October 9, 2023

Re: Starbucks
Project #: PR-2023-008767
Application #: SI-2023-01512

Please find the following responses addressing comments received in a letter dated October 4, 2023. In an effort to address your comments concisely and simplify your review of these development plans, we have summarized your comments and our responses below. Your comment is listed first, followed by the response in Bold.

**IDO Waiver Note**

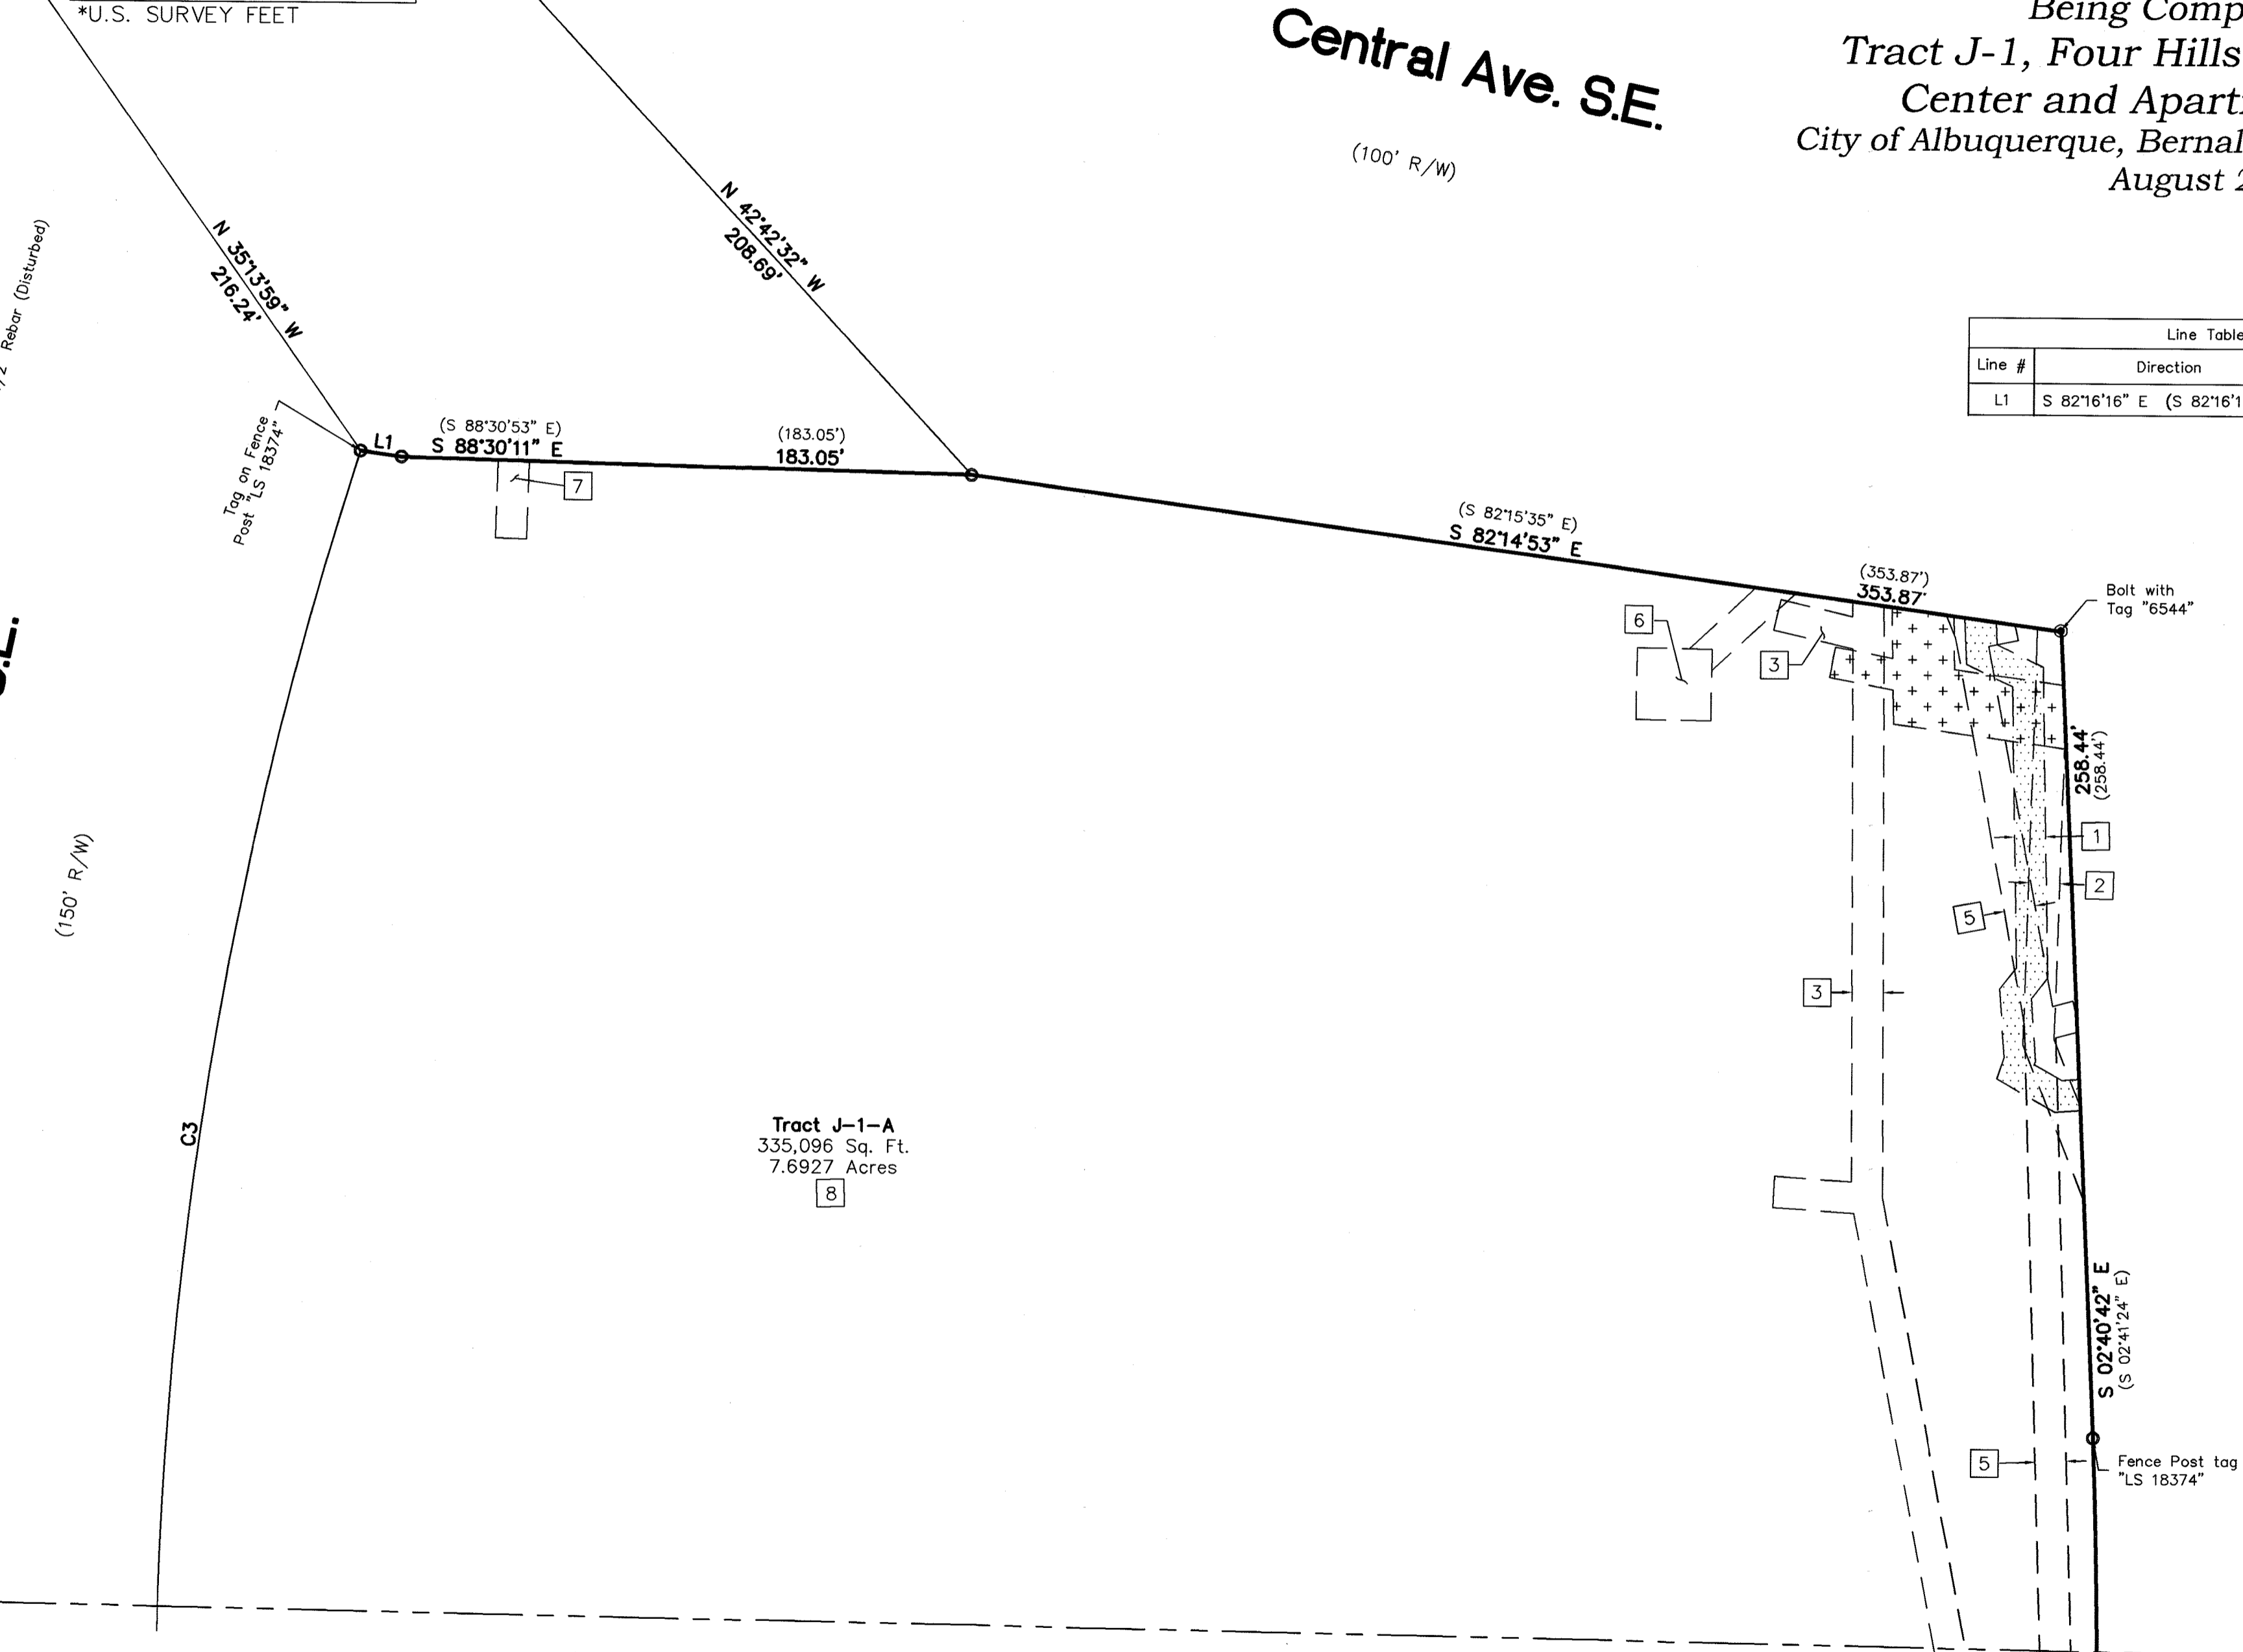
2. Tramway and Wenonah are major collectors within a center and therefore require 10' sidewalks. You may request a waiver with a justification letter if you cannot provide the 10' sidewalk.

- The site is located in the Four Hills Village **Activity Center** along Central Ave. and Tramway Blvd. Also within an MT-Major Transit Corridor.
*Per the DPM, Table 7.2.29 and per the Transportation Engineer:
Tramway and Wenonah are major collectors within a center and therefore require 10' sidewalks.*
*Applicant is submitting a waiver to sidewalk width.

Applicant Response: A Sidewalk Waiver has been submitted and approved by the DHO. See attached approved plat. On page 2 "IDO Waiver Note".

Applicant Response: A Sidewalk Waiver has been submitted and approved by the DHO. See attached plat. On page 2 "IDO Waiver Note".

A2 MAJOR AMENDMENT TO EXISTING SITE DEVELOPMENT PLAN
SCALE: 1:40

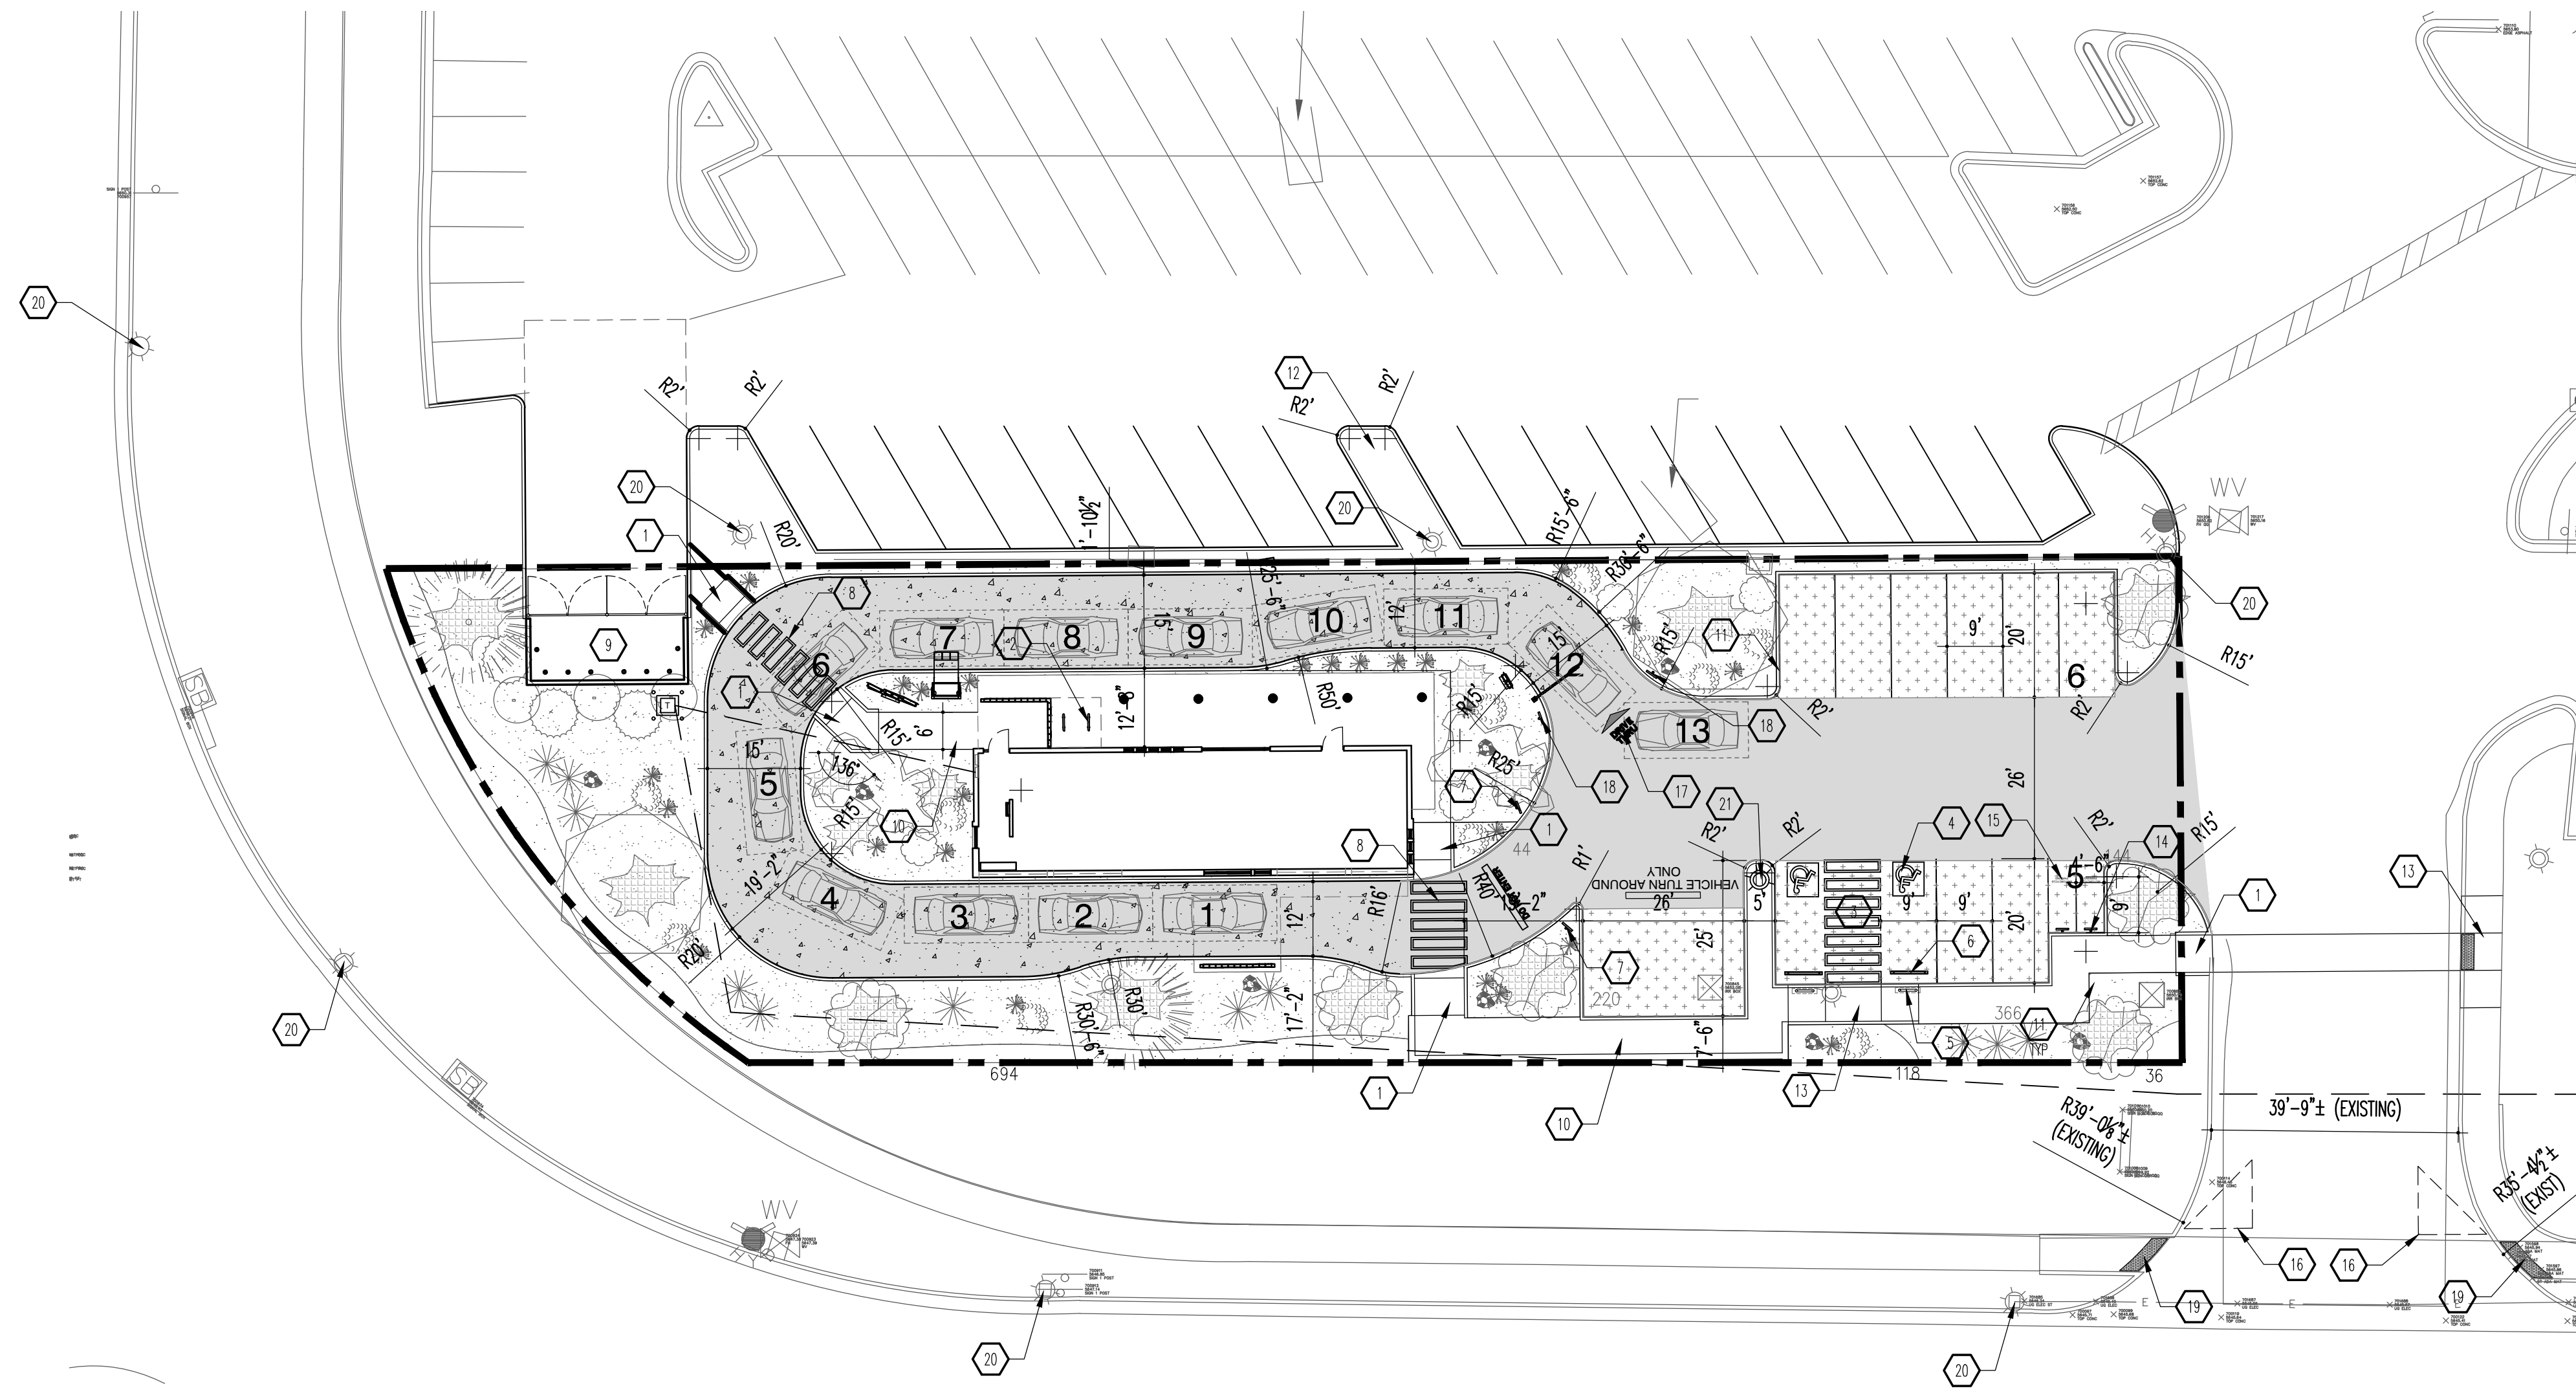
A. *Provided bicycle parking total shall be added.*

The applicant shall update the Major Amendment sheet to reflect the provided bicycle spaces. This was only included on the Site Plan sheet associated with the request. All amendments shall be reflected on the Major Amendment Sheet.

Applicant Response: Bicycle spaces have been included in the Major Amendment sheet see “Existing Smith’s Parking” table and “Proposed Coffee Shop with Drive-thru Parking” table.

PROJECT TITLE: **STARBUCKS - TRAMWAY**
200 TRAMWAY BLVD. NE
ALBUQUERQUE, NEW MEXICO 87123
JOB NO.: **SF-TRAMWAY**
PROJECT MANAGER: **DEVIN NGUYEN**
DRAWN BY: **DIN**
DATE: **25 Jun 2023**
SCALE: **AS NOTED**
SHEET TITLE: **SITE PLAN**
SHEET NO.: **AS101**

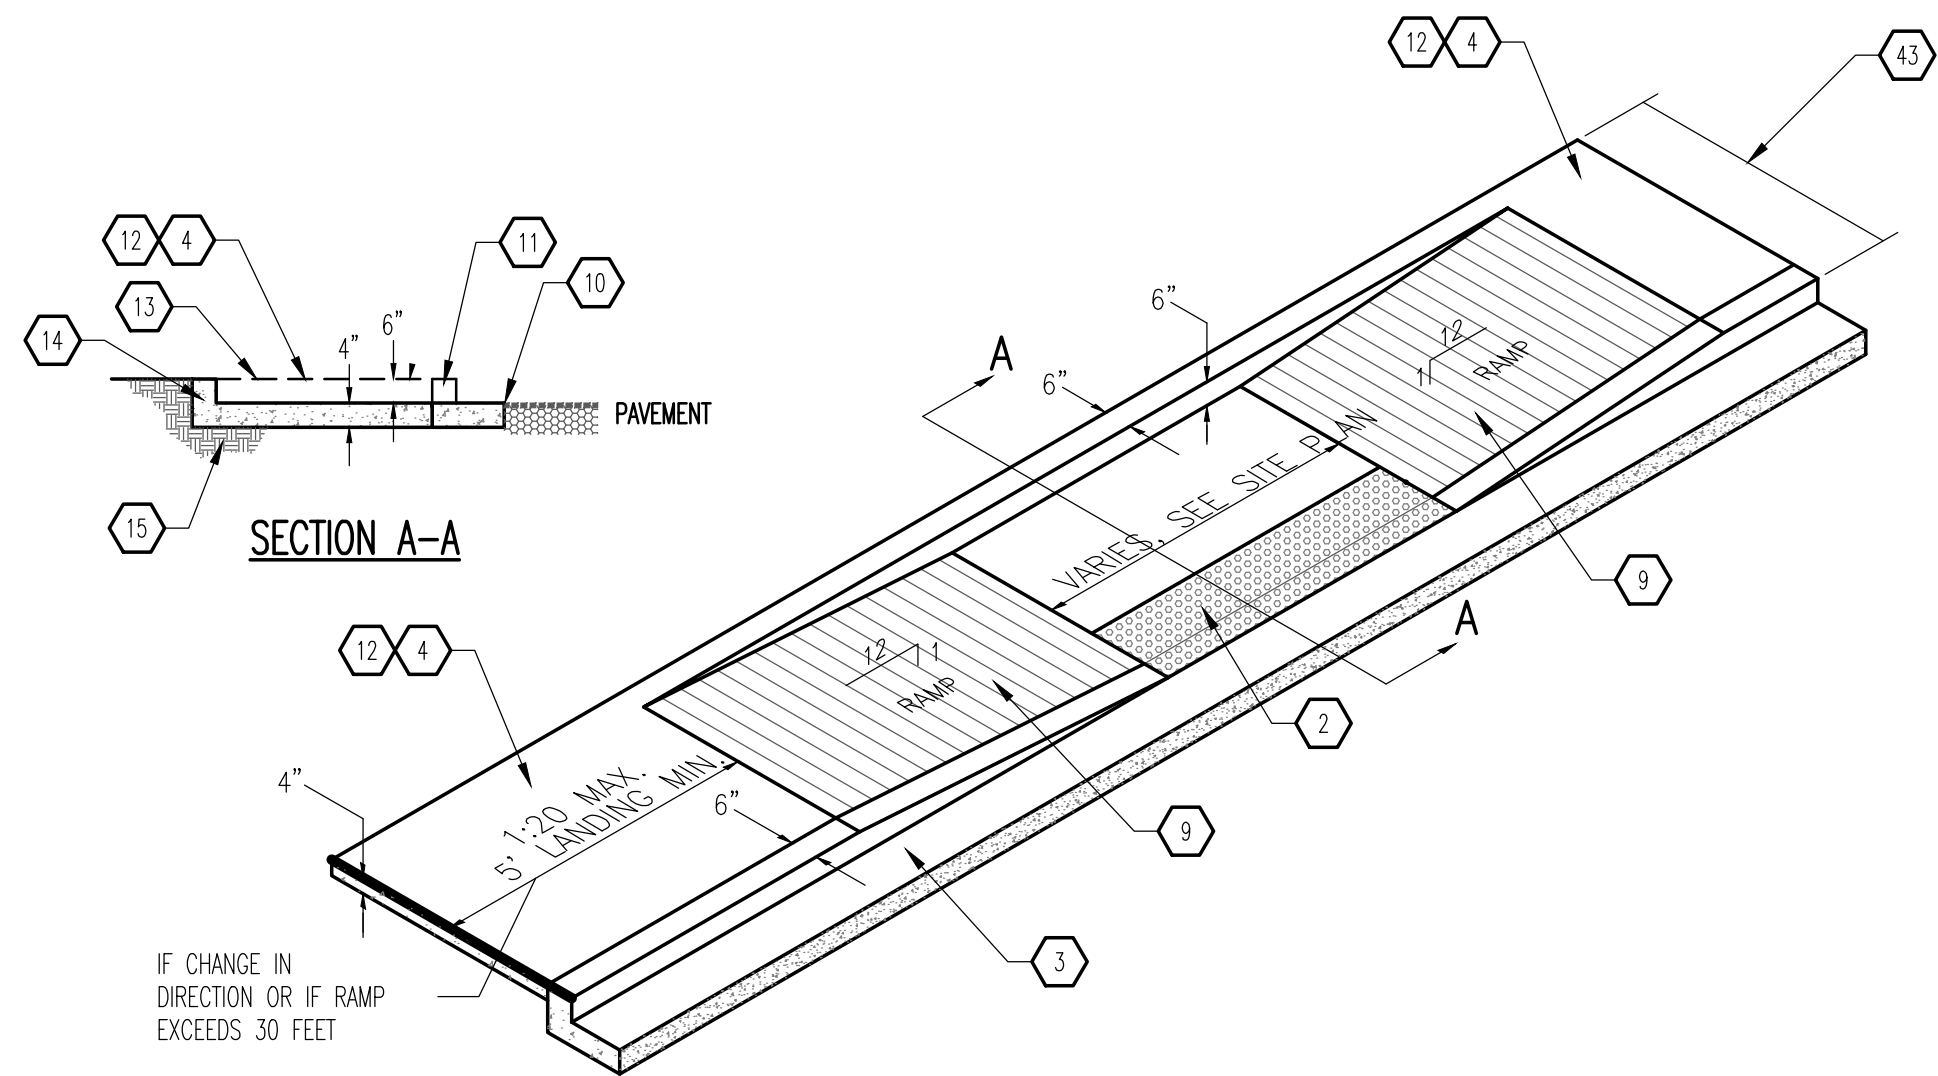
14-16-5-3(D)(3)(b)(3) On site pedestrian path ways from the Wenonah Ave street side and pathway from the north side parking area. Not the driveway area

14-16-5-5(D)(2) Motorcycle spaces shall be located in a conveniently, highly visible, well lit area.

Applicant Response: A pedestrian path is being provided from the Wenonah. See below on how the path in being provided (shown in red). It was determined the best path because the existing grades that exist on site.

Applicant Response: The motorcycle spaces have been located in a conveniently, highly visible, well lit area. This is a small site and the spaces can be seen from the front of the building. A additional light pole is being proposed in the parking area.
